***Mixed Use Development at 23 - 25 Ashton Avenue The Entrance (SSD-84190958) (Central Coast)–
Council Submission***

I refer to your email of 8 May 2026 whereby Council received a request to provide comments on SSD-84190958. In response, Council provides the following comments regarding the proposed development:

DRAWING NO. DD103
ISSUE NO. F
SCALE 1:250@A3

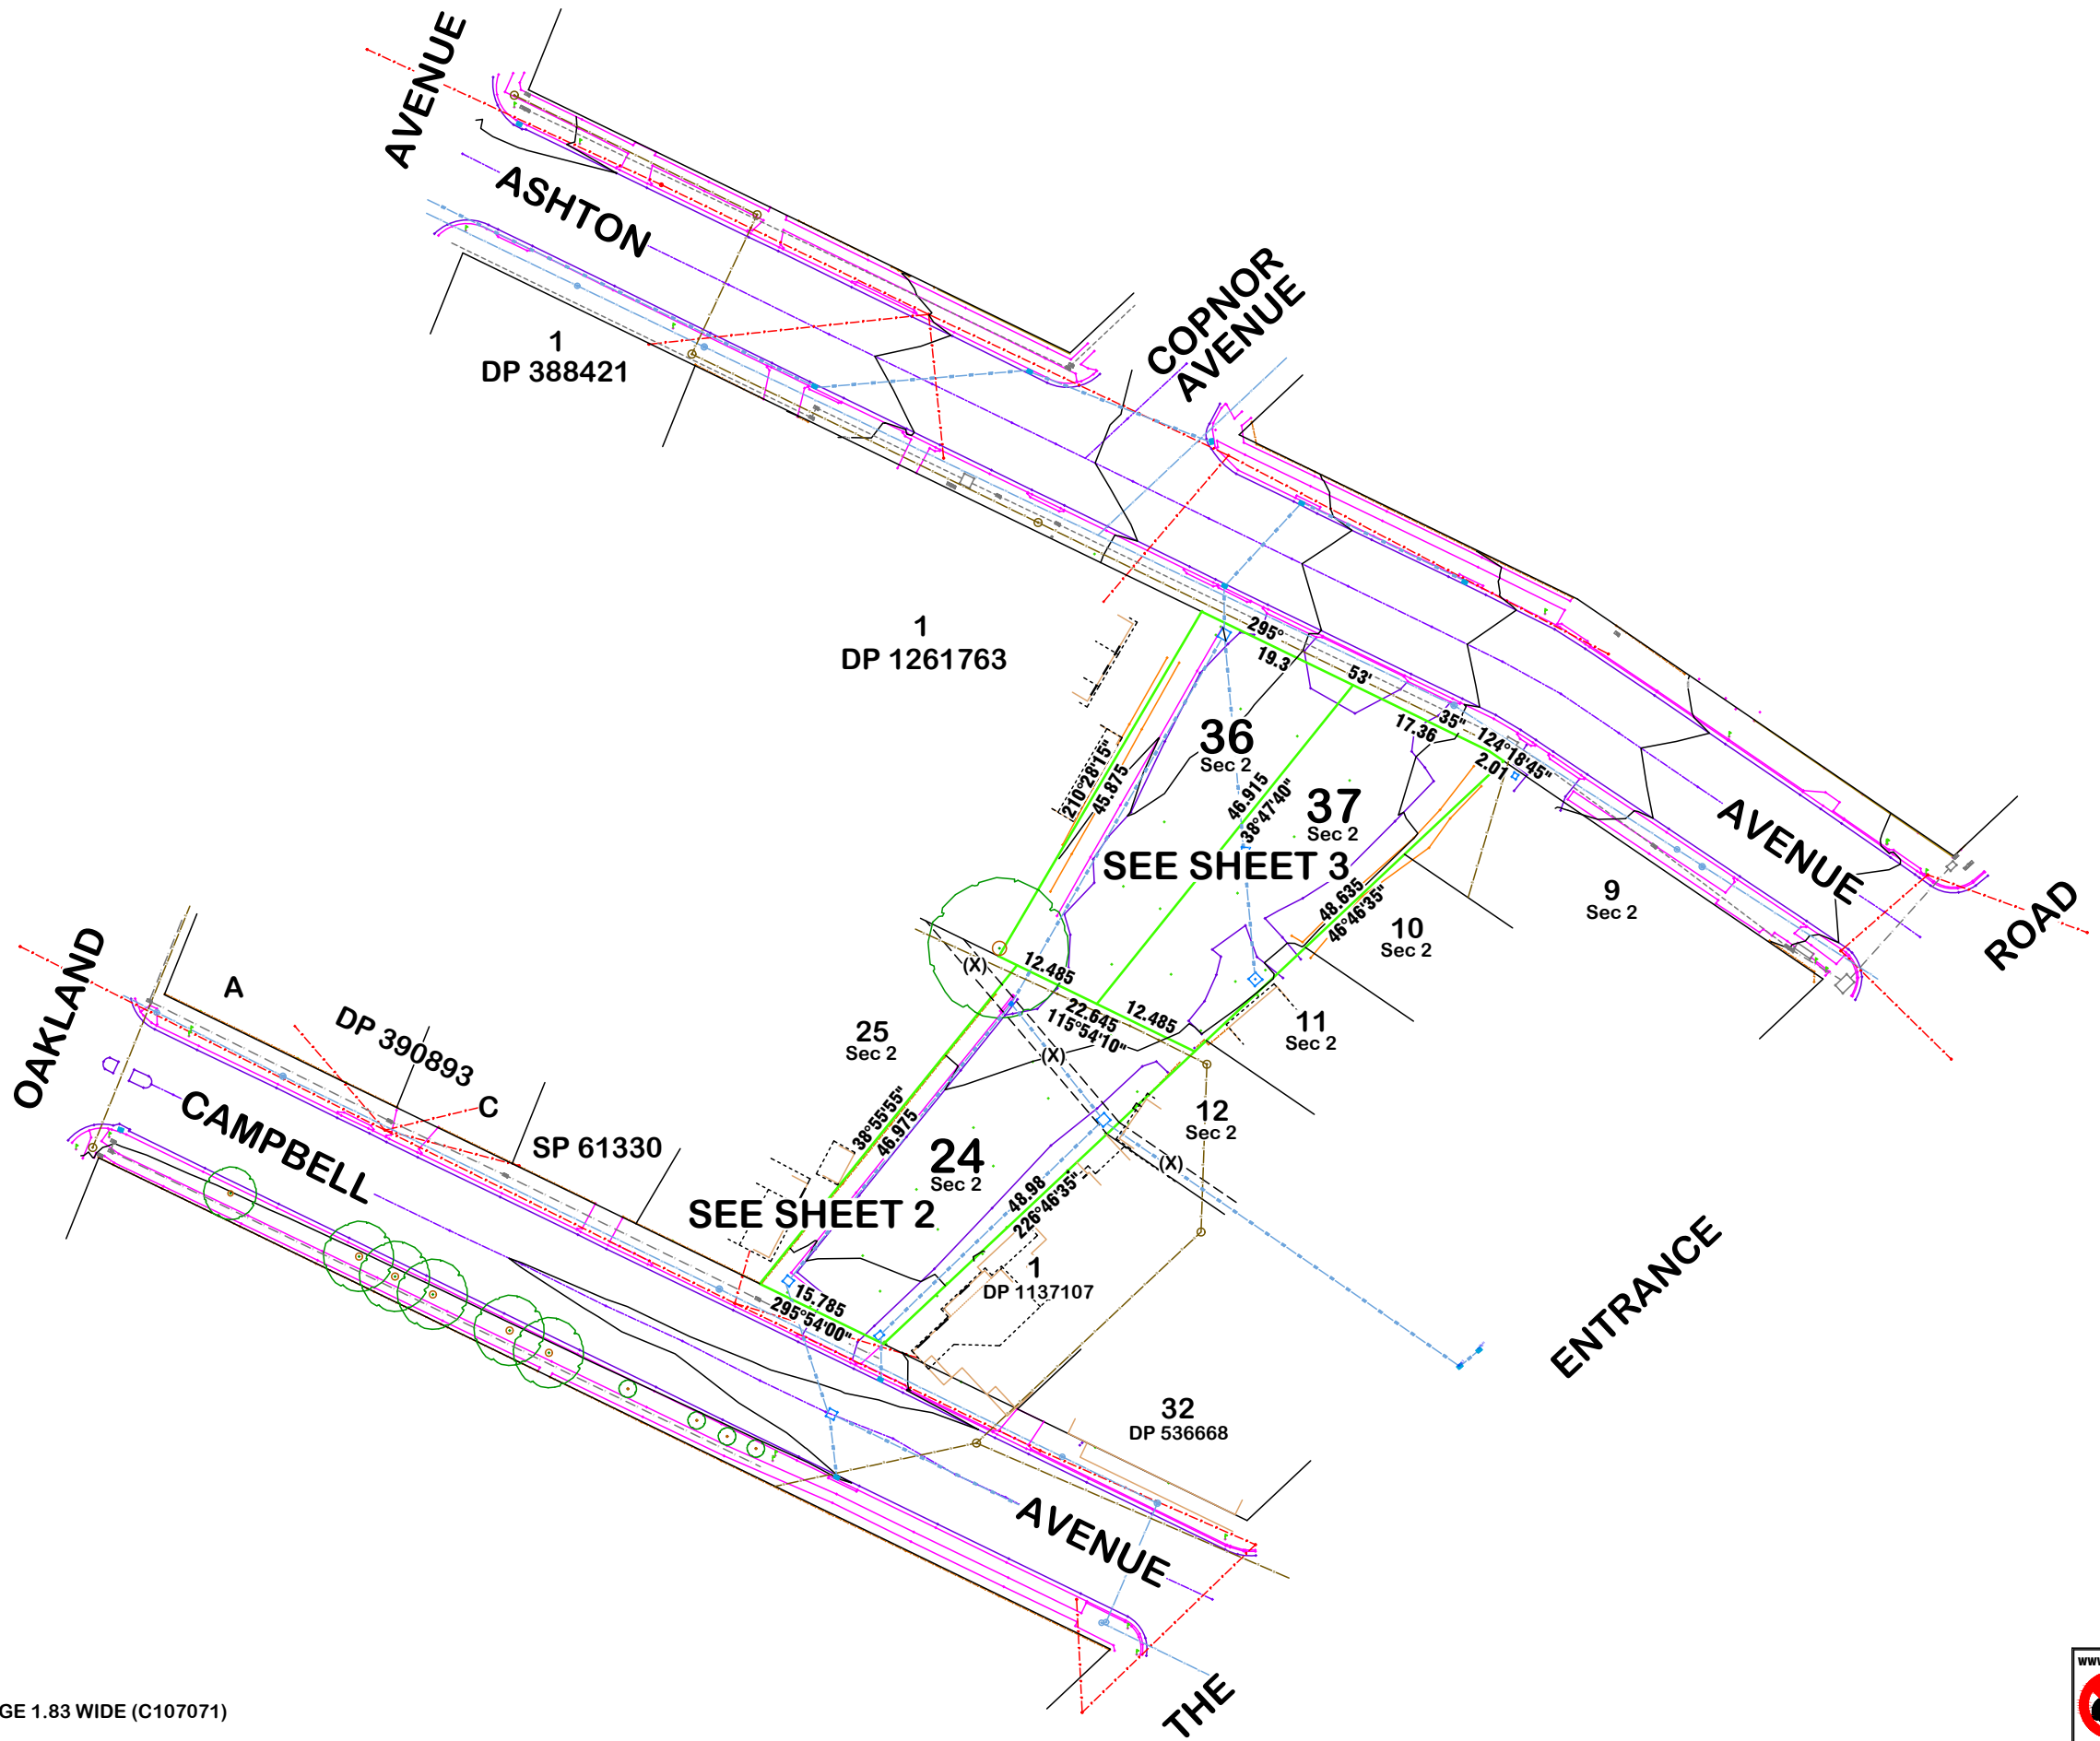
- The applicant is proposing gates at either end of the development. This raises the question as to how the lots that front The Entrance Road, which have their access through the site, have unrestricted access.

- Access to the proposed bulk waste storage area needs to be clearly indicated. It is unclear where the doorway is to get into the area, it must not open out into the proposed carpark adjacent to the room.

ExP1 TO P12
SCALE HORIZONTAL 1:100, VERTICAL 1:200

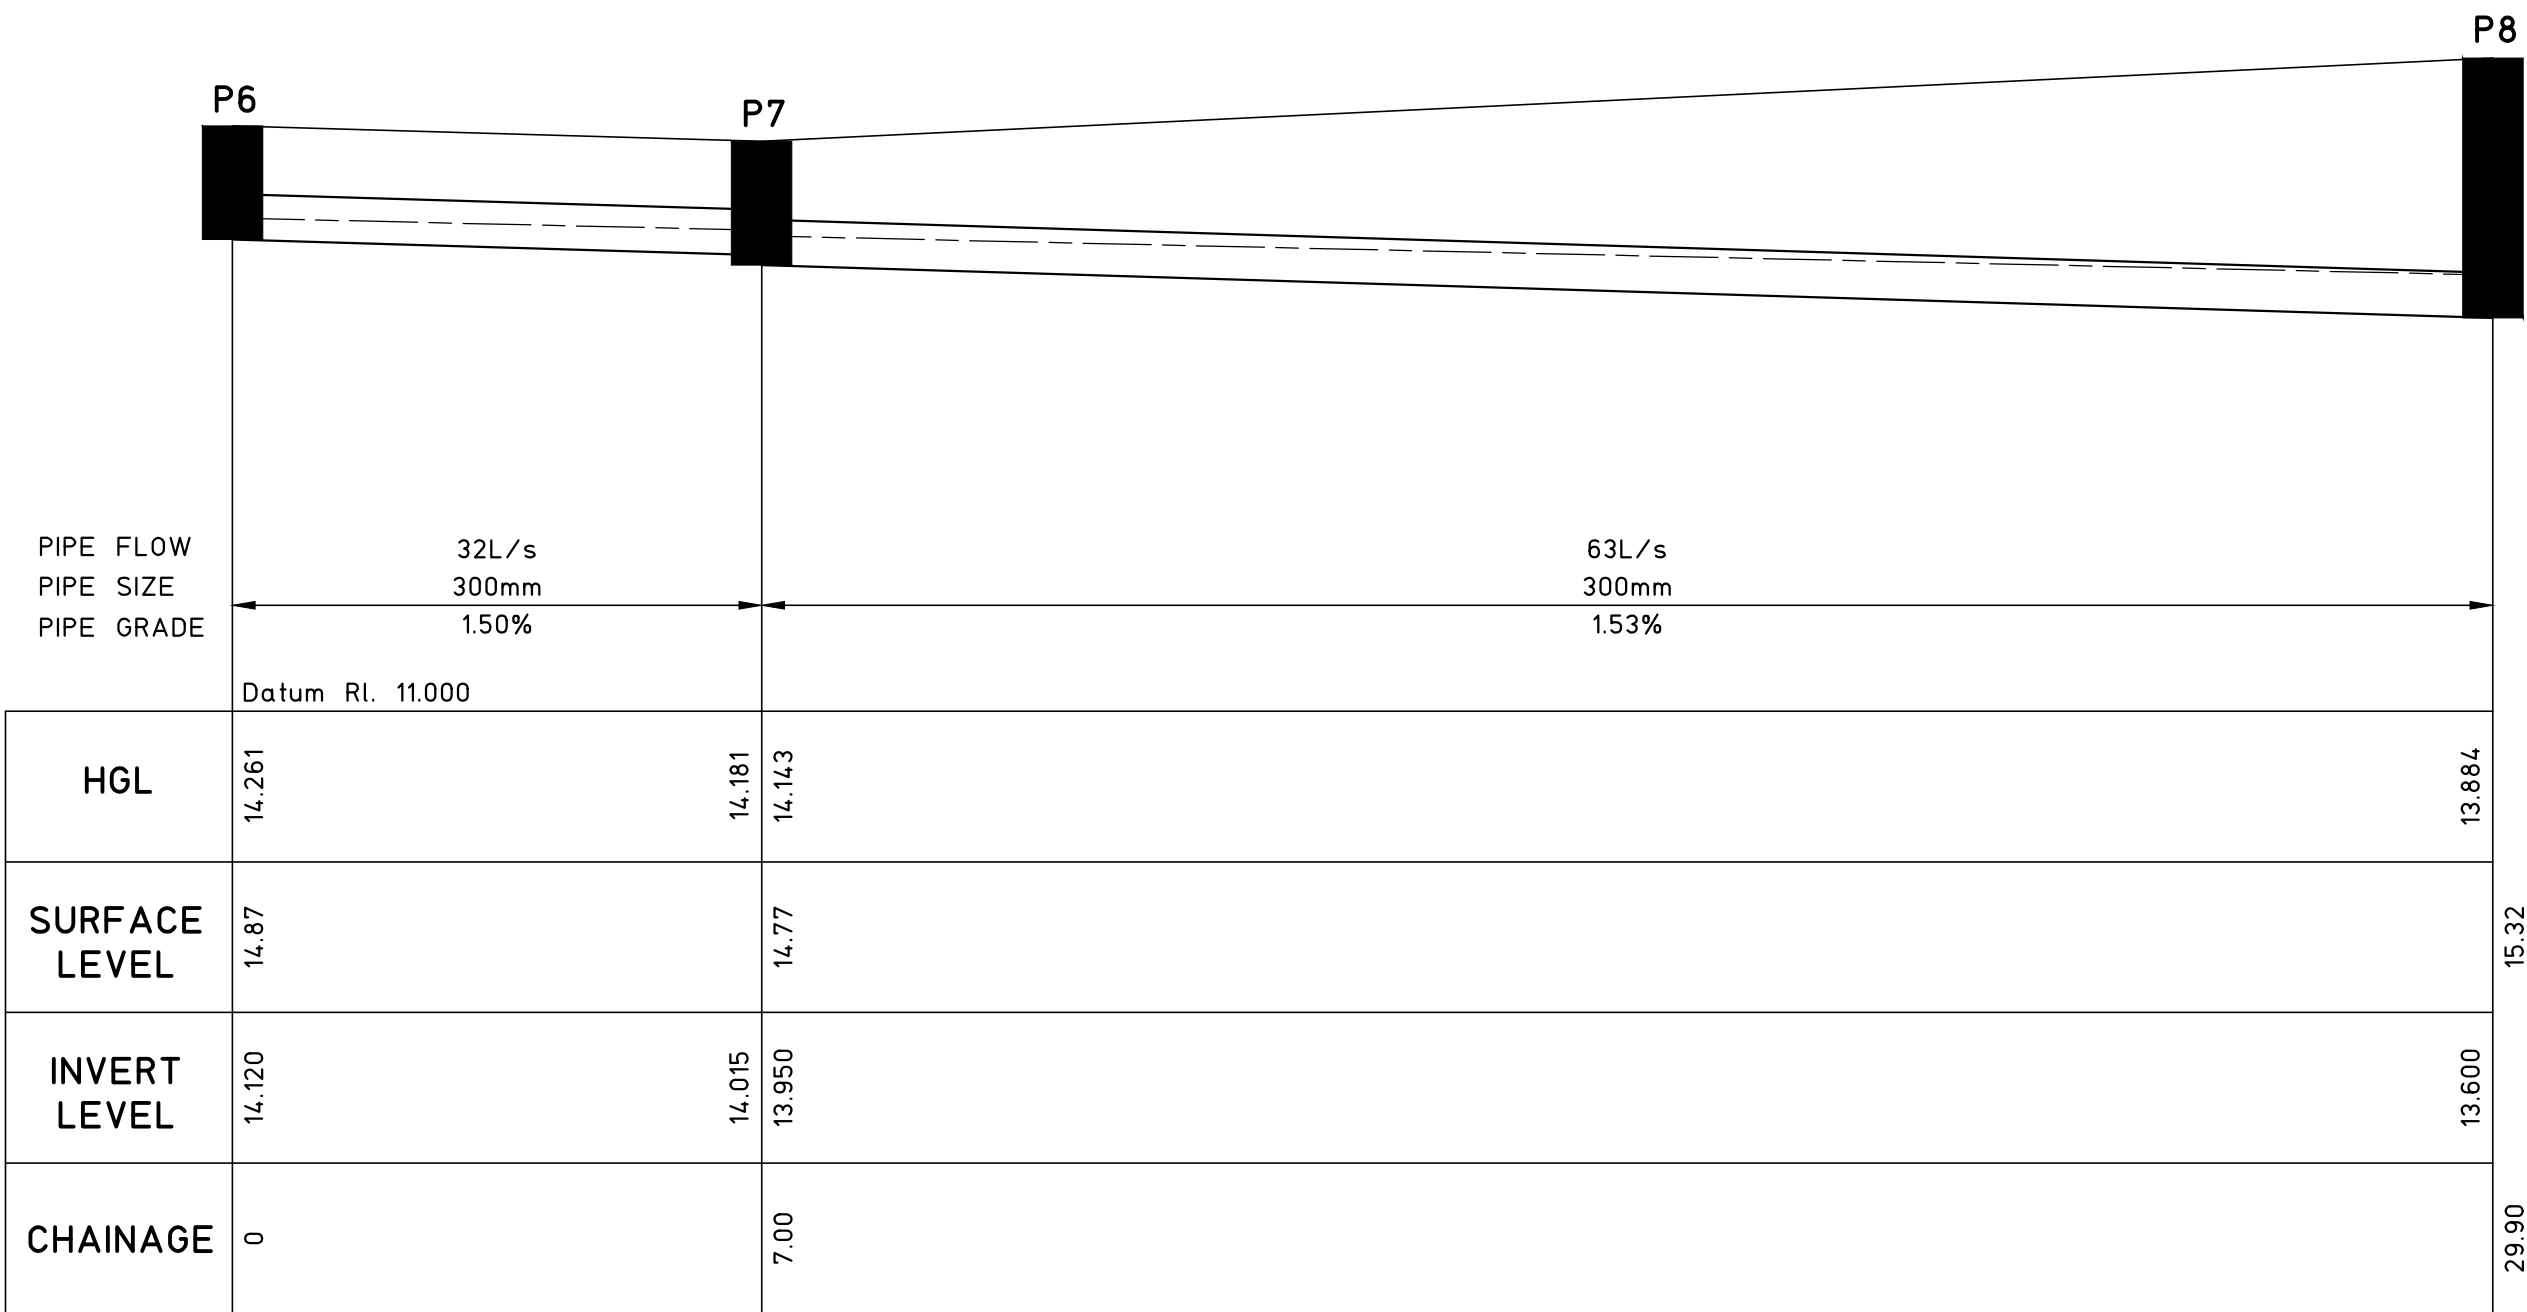
- Horizontal separation between the Council drainage line from Campbell Avenue and the proposed new 225 diameter line is required.
